United Utilities Water PLC
Developer Services & Planning
Thirlmere House
Lingley Mere Business Park
Lingley Green Avenue
Great Sankey
Warrington WA5 3LP

Your ref: 07/2012/0484/REM
Our ref: DC/12/3464
Date: 28-SEP-12

Location: The Homestead, Whaley Road, Wilpshire, Blackburn Lancashire BB1 9LL
Proposal: Creation of additional Car parking

PROPOSED SITE PLAN - SCALE 1:200

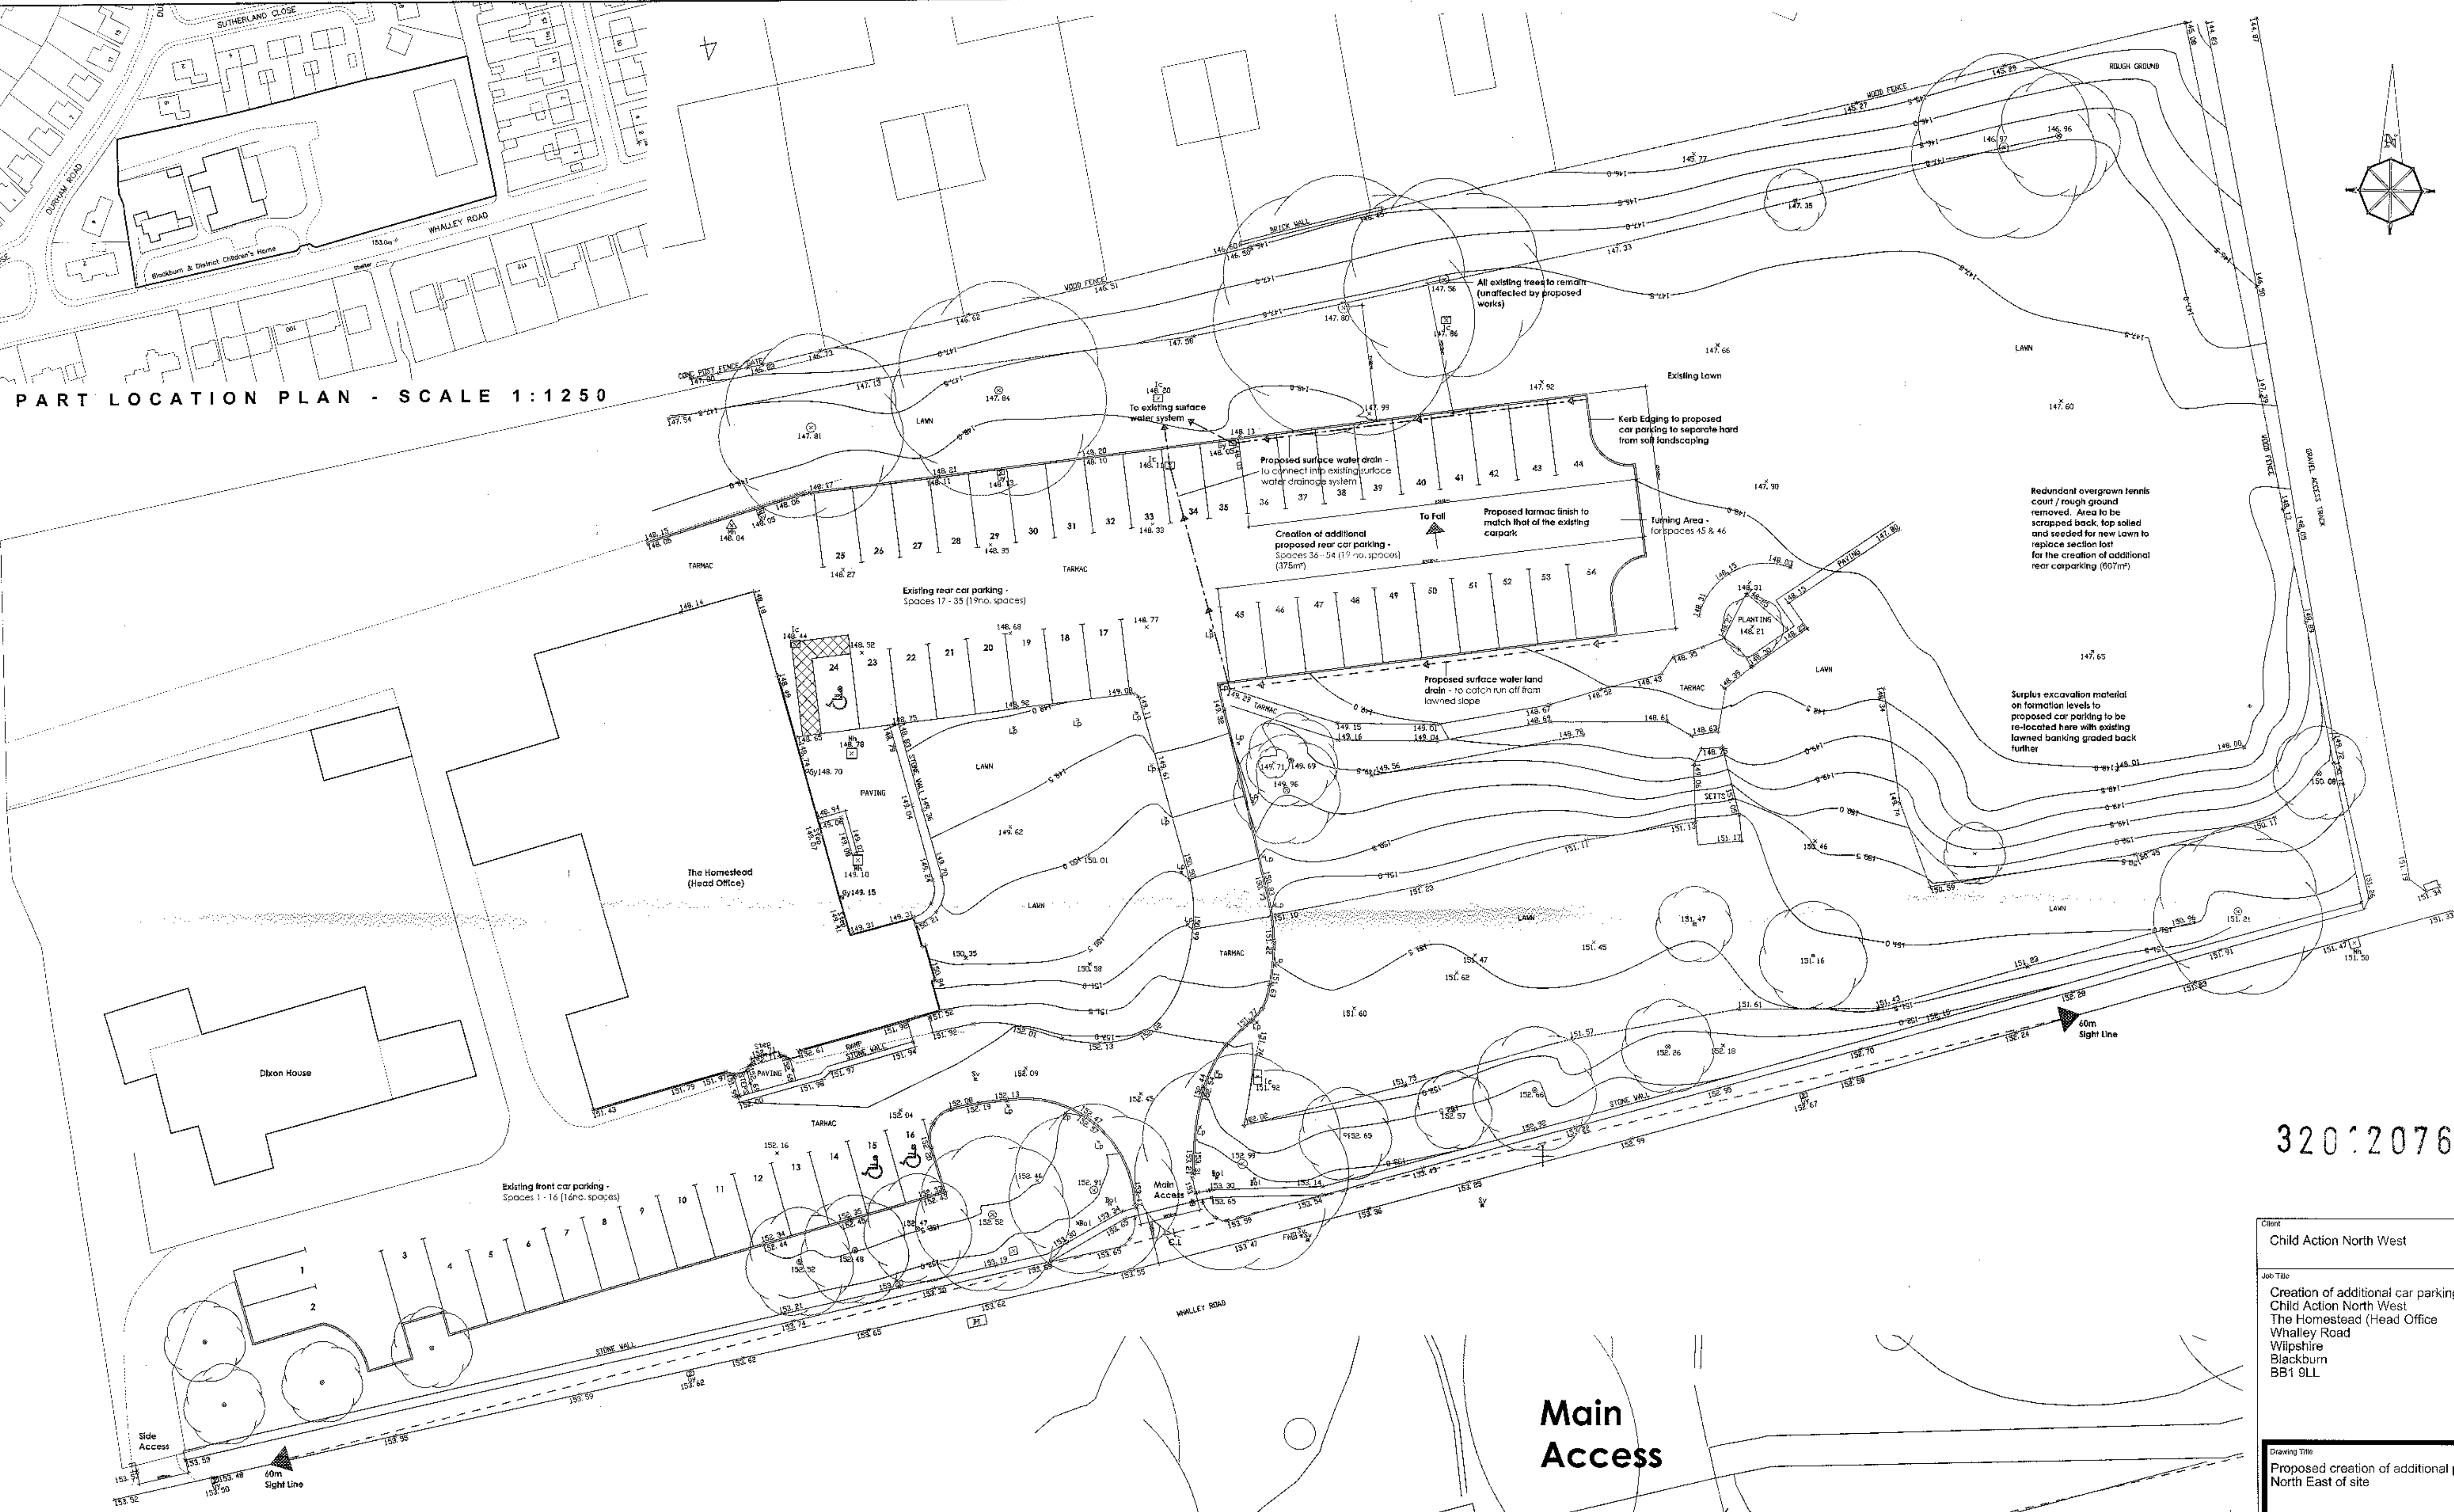
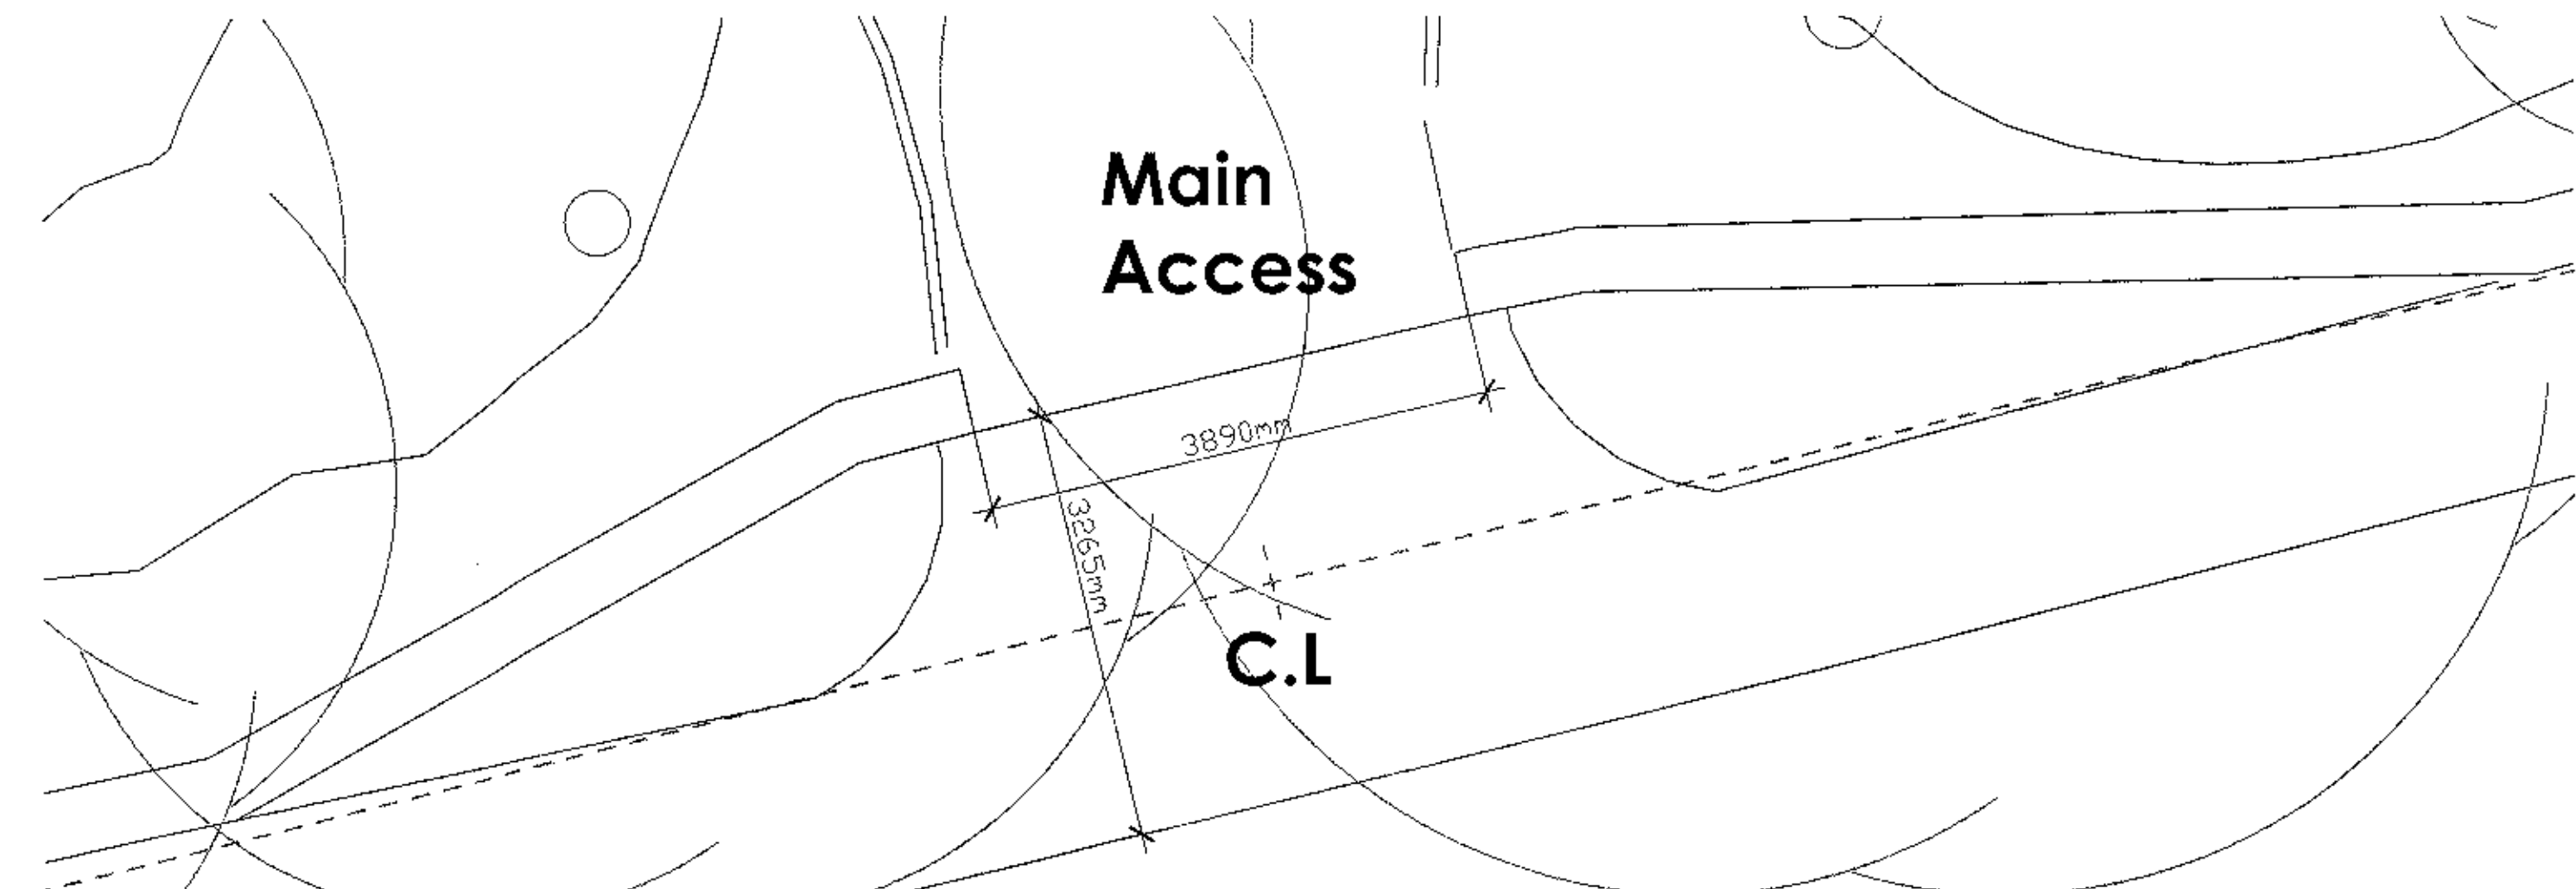
The developer has no right to connect highway drainage to the public sewer

- Notwithstanding any indication on the approved plans, no development approved by this permission shall be commenced until a scheme for the provision and implementation of a surface water regulation system, restricting residual surface water discharge to 5 l/s or Greenfield runoff whichever is the greater, has been approved by the Local Planning Authority. The scheme shall be completed in accordance with the approved plans.

- Notwithstanding the details of the submitted plans, the proposed car park shall be constructed using permeable materials on a permeable base, the details of which shall be submitted to and approved by the Local Planning Authority prior to the commencement of the development. The development shall be carried out using the approved materials and shall be retained thereafter, unless otherwise agreed in writing by the Local Planning Authority.
